DECISION DELEGATED TO DEVELOPMENT MANAGER

Application No: H13-0348-21 **Applicant:** Postland Developments

Proposal: Details of construction management and prevention of mud deposits on highway (Conditions 21 & 23 of H13-0844-17)

Location: Chapel Walk Roman Road Moulton Chapel

Proposed compound plan of site

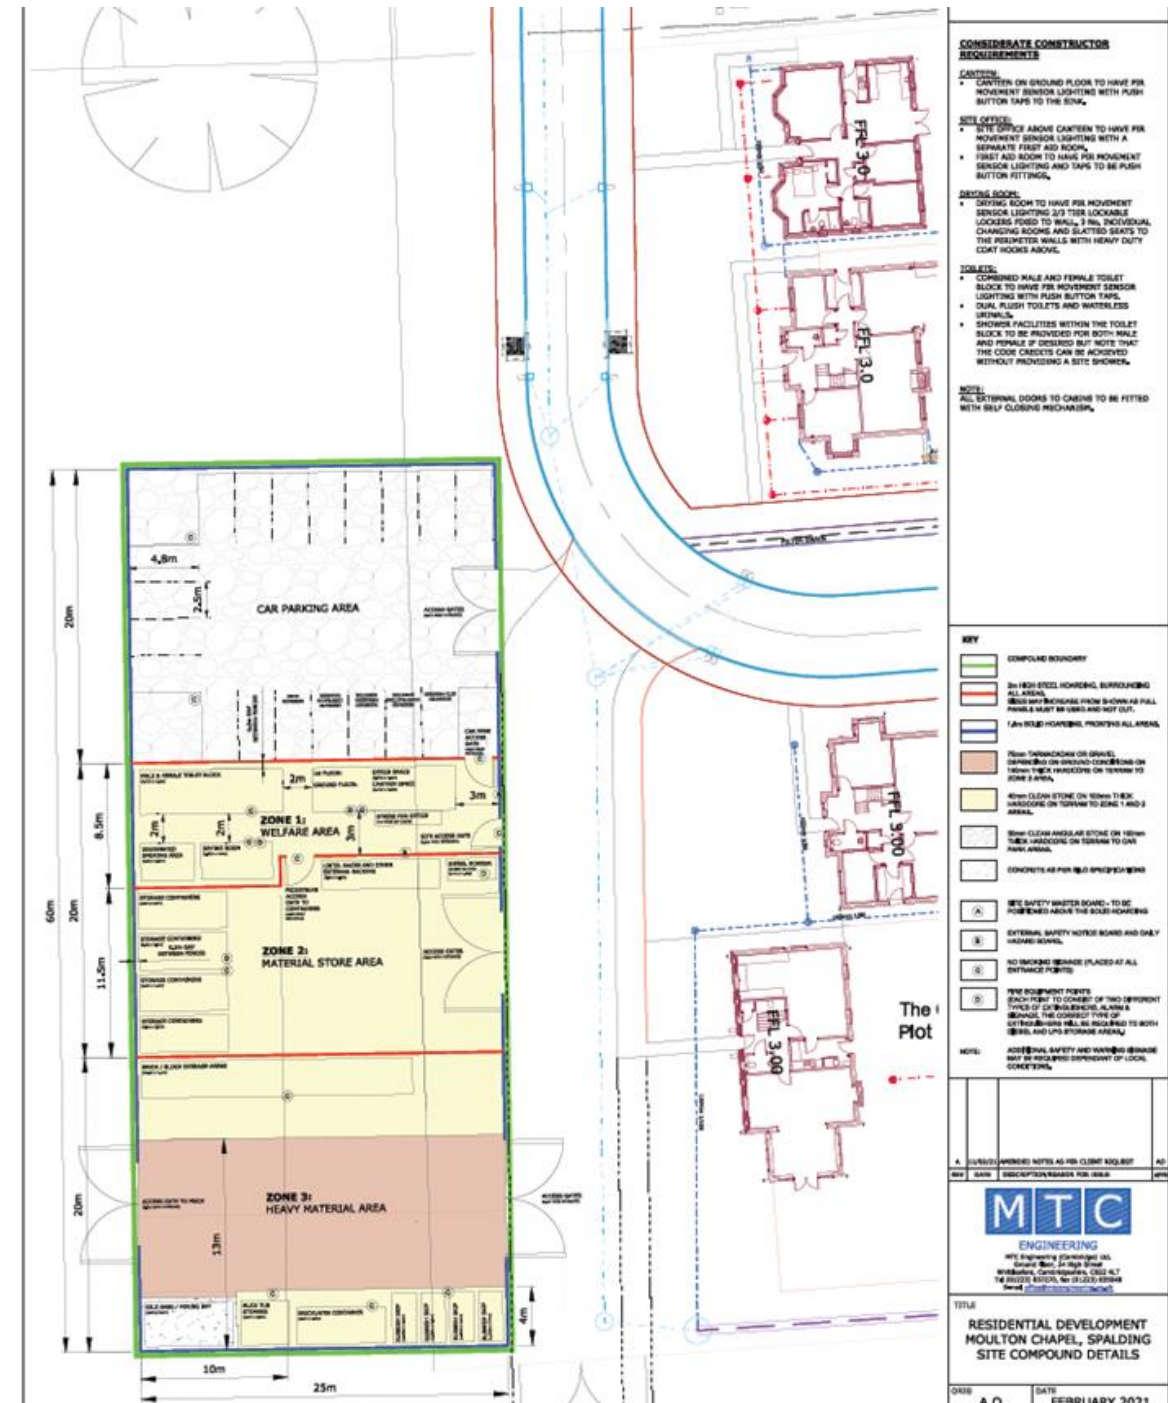
Cllr Woolf - On page 17 of this document, the applicant states the following under the section Access/Egress/Control of Mud:

"An internal road is to be created as part of the initial works on the project to allow adequate access off Woodgate Road, using the wider entry as the designated route. All parties needing to attend site will be informed this is the access to use with signage situated to inform all of the route. This will provide a safe means of access and egress to the site compound and drop off areas. The site's main access and egress is planned to change during the project following the completion of the Roman Road entrance. Delivery vehicles will then enter from Roman Road and exit via Woodgate Road rather than two-way traffic on Roman Road which all other vehicles will utilise. This will reduce the localised congestion and create a more efficient traffic flow around the site and surrounding residential roads".

Given the internal road has already been created under permitted development rights, this statement is somewhat presumptuous. It is also incorrect as if anything localised congestion will increase as Woodgate Road quite simply can't handle that amount of traffic, and nor should it. A further incorrect comment in the statement is Woodgate Road is a wider entry than what Roman Road will be. This is not true and was clearly evident when an articulated vehicle took over 30 minutes to manoeuvre back and forth to gain access into the Woodgate Road entrance. Put quite simply, the Woodgate Road access should be off limits as the road is unable to cope with this construction traffic. Were this access not there, then Roman Road access would have been the one and only option. Please note my objection to this section of the statement and I hope to see just one access/egress point for the development which will be off Roman Road.

- Roman Road better suited to HGVs than Woodgate Road
- Several HGVs have been observed using the the western fork of Woodgate Road in spite of it being clearly signed as Unsuitable for HGVs
- The hauliers involved have demanded of residents to move vehicles to allow easier access

Concerns have been raised locally about the suitability of Woodgate Road for construction and delivery traffic. The applicant initially proposed that vehicles would enter the site via Woodgate Road and following the completion of the access at Roman Road, vehicles would then enter via that road, and exit via Woodgate Road in a one-way system. In response to the concerns raised, the applicant has revised their intentions and they are now proposing to cease use of the Woodgate Road access on 31st May 2021, after which only the Roman Road access will be used.

In light of the above comments by consultees and the revised intention of the applicant to cease use of the Woodgate Road access on 31st May 2021, it is not considered that it would be reasonable to withhold consent.
